Re: Waterbury House, Ford, Sussex – Consultancy letter

Please find below the following heritage information and advice to assist in your design proposal and application for the construction of five flats in the grounds of Waterbury House.

This letter comes as a follow up to the letter issued on 10th December 2017, which commented on your previous design proposals. This letter now comments on revised proposals that have been made to take into consideration, comments made by the local planning authority.

Proposed West Elevation

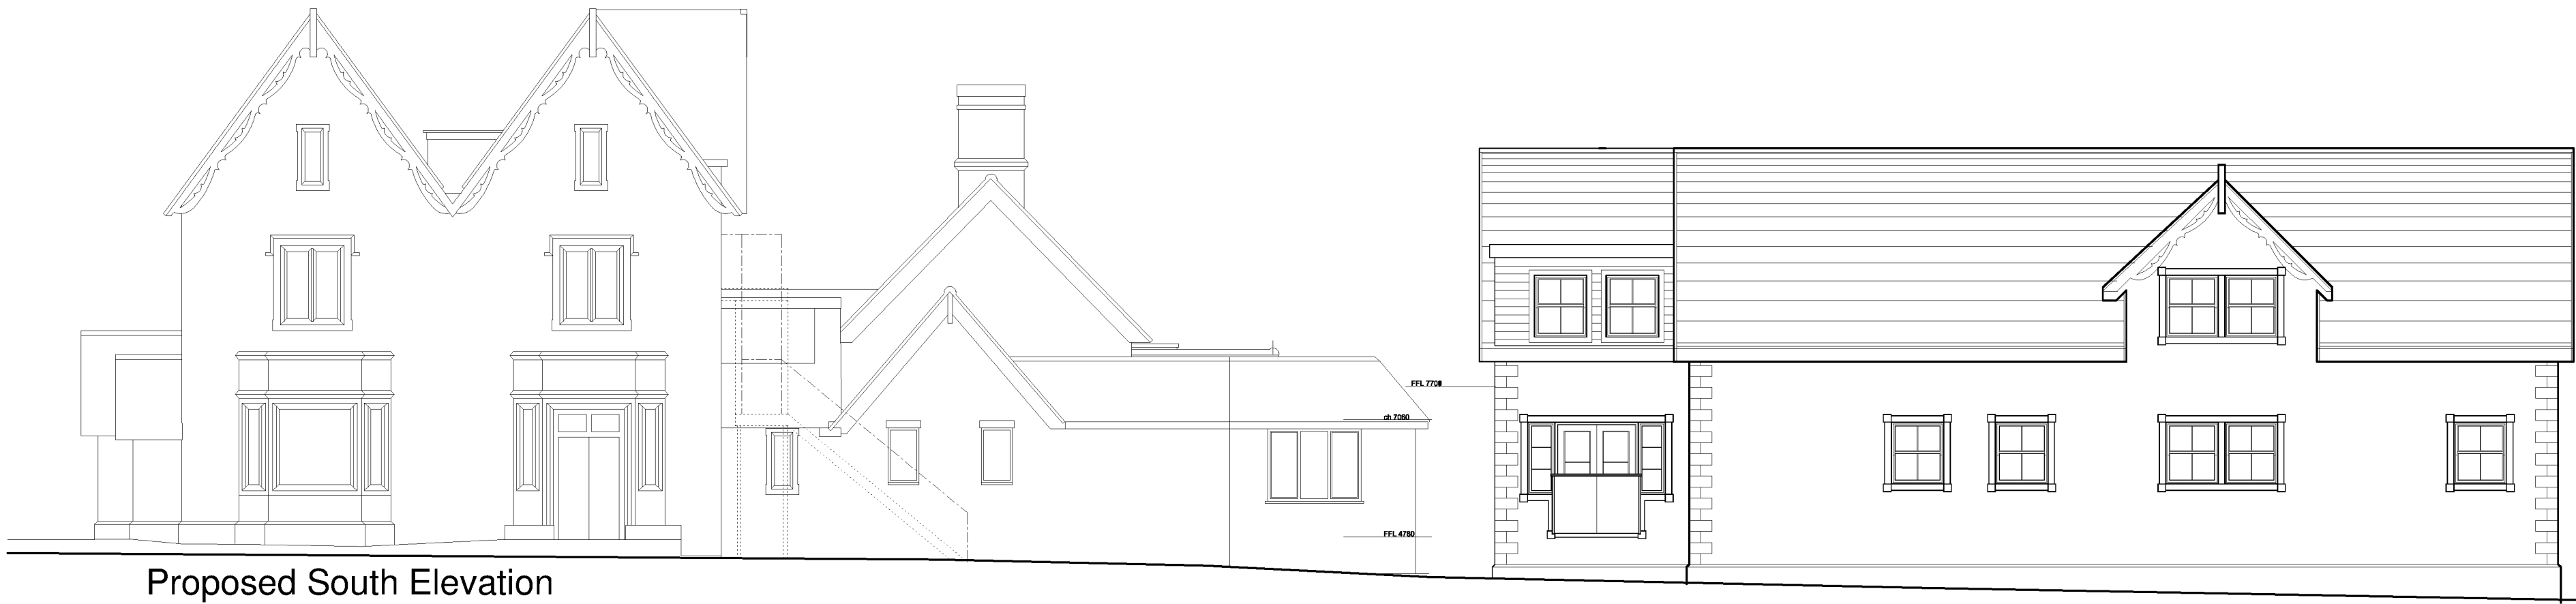
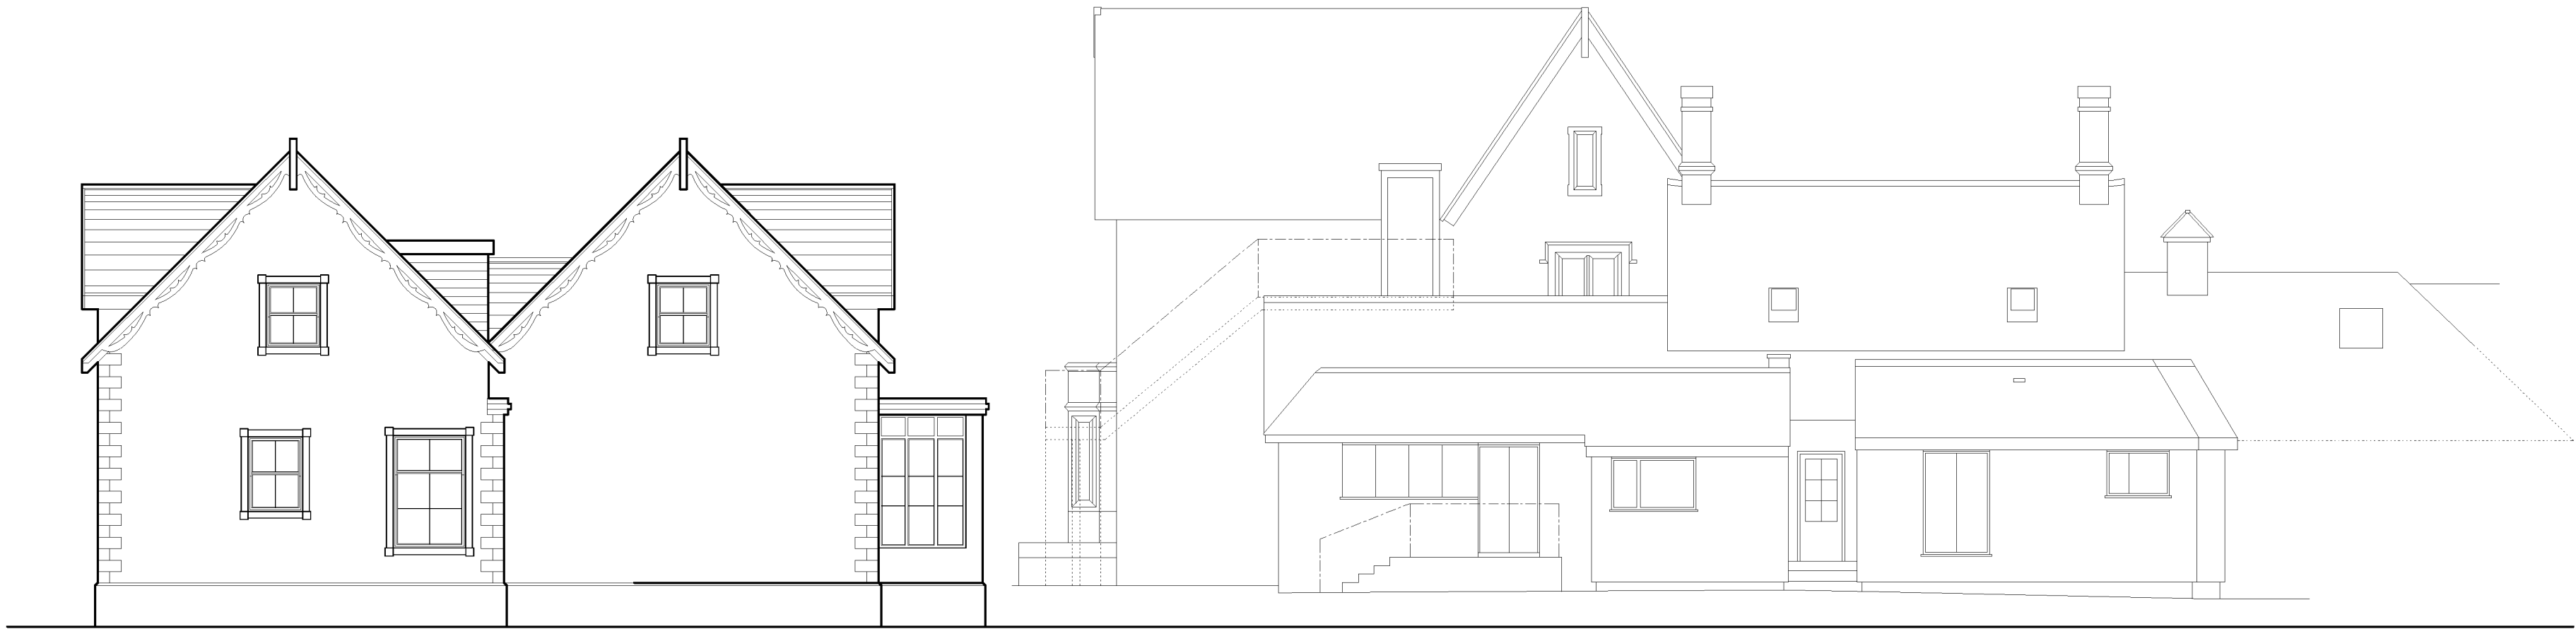
The north elevation of the proposal will be the longest elevation in total, although it is broken up into sections that are off-set from each other, to break up the elevation. The west section is in line with the south face of the main house, while the central and east sections are stepped back to the south of this. The north elevation will contain a glazed porch entrance and two gabled dormer windows on the west section that would be looking out over the garden to the east of the main house, three windows at the central section and four windows on the east section. The 2010 scheme had a long west section with four-pane windows and French windows, with an east section with a fully glazed wall facing north. The 2017 scheme had a large gabled dormer, with a long, flat-roofed dormer window and French windows. Therefore the current proposal has less dormer windows, that are smaller and would not dominate the appearance of the elevation.

On the east elevation, there will be a gable end window looking east on the north section and an adjoined south section, with the gabled dormer roofs of the north and south elevations

visible to either side. The 2010 scheme had three windows and French windows to one of the gable ends, a glazed link and a window to the other gable end. The 2017 scheme east elevation had a gable end window in the north section and three windows in the south gable wall, with the large dormer roofs of the north and south elevations almost matching the apex of the main roofs. Therefore, the dormer gabled roofs of the current proposal will be less visible from the east elevation than those of the 2017 scheme.

On the south elevation, there will be one small gabled dormer window looking south on the west section, with two small windows to the central and east sections. The elevation is articulated with the off-setting of each section, thereby breaking up its span. The 2010 scheme had a west section with a row of four dormer windows and a pair of French windows, with four-pane windows to the long east section. The 2017 south elevation had a double dormer window on the west section and a large gabled dormer window on the east section. Therefore, the gabled dormer window of the current proposal is smaller than those of the 2017 scheme.

On the west elevation, there are three windows on the north section, together with the gabled dormer windows of the north and south elevations visible, and a south section with three windows. The 2010 scheme included one flat-roofed dormer window facing south, so it could not be seen from the house, a south section with French windows and the two sections were to be joined with glazed links. The 2017 scheme west elevation had the north and south sections adjoined, with the large gabled dormer windows of the north and south elevations clearly visible. Therefore, the current proposal has smaller gabled dormer windows by comparison.

The response comments on the 'bulky roofscape, comprising multiple dormer windows, with a max ridge height of 16,000 mm approx.'. The scale on the drawings had been misinterpreted, as the height of the existing building from floor to apex is 10,580 mm. The current proposal has addressed this concern, through reducing the apex roof height to 7,700 mm and thereby making the proposed building subservient to the existing building. It has also reduced the size of the gabled dormer windows on the north elevation and one on the south elevation.

The response states there is a 'large amount of glazed guarding visible to the west and south elevations'. The fenestration on the west elevation (numbering three windows on the north section and two windows on the south section) is markedly less than the 2010 scheme, as it avoids the glazed link sections to either side. The south elevation (numbering one dormer window and eight other windows) has significantly less glazing than the approved 2010 scheme, with less dormer windows. If 'glazed guarding' relates to glass panel fencing, then this can possibly be substituted for a more traditional fence.

The overall massing of the building of the current proposal has been articulated with a variety of rooflines and off-setting of sections to break up the footprint and elevations. The roofscape, which was quoted as 'dominant', now includes apexes of various heights that step down, as the ground level descends gently to the east of the site. In addition, the reduced size and number of gabled dormer windows will lessen the impact of the roofscape.
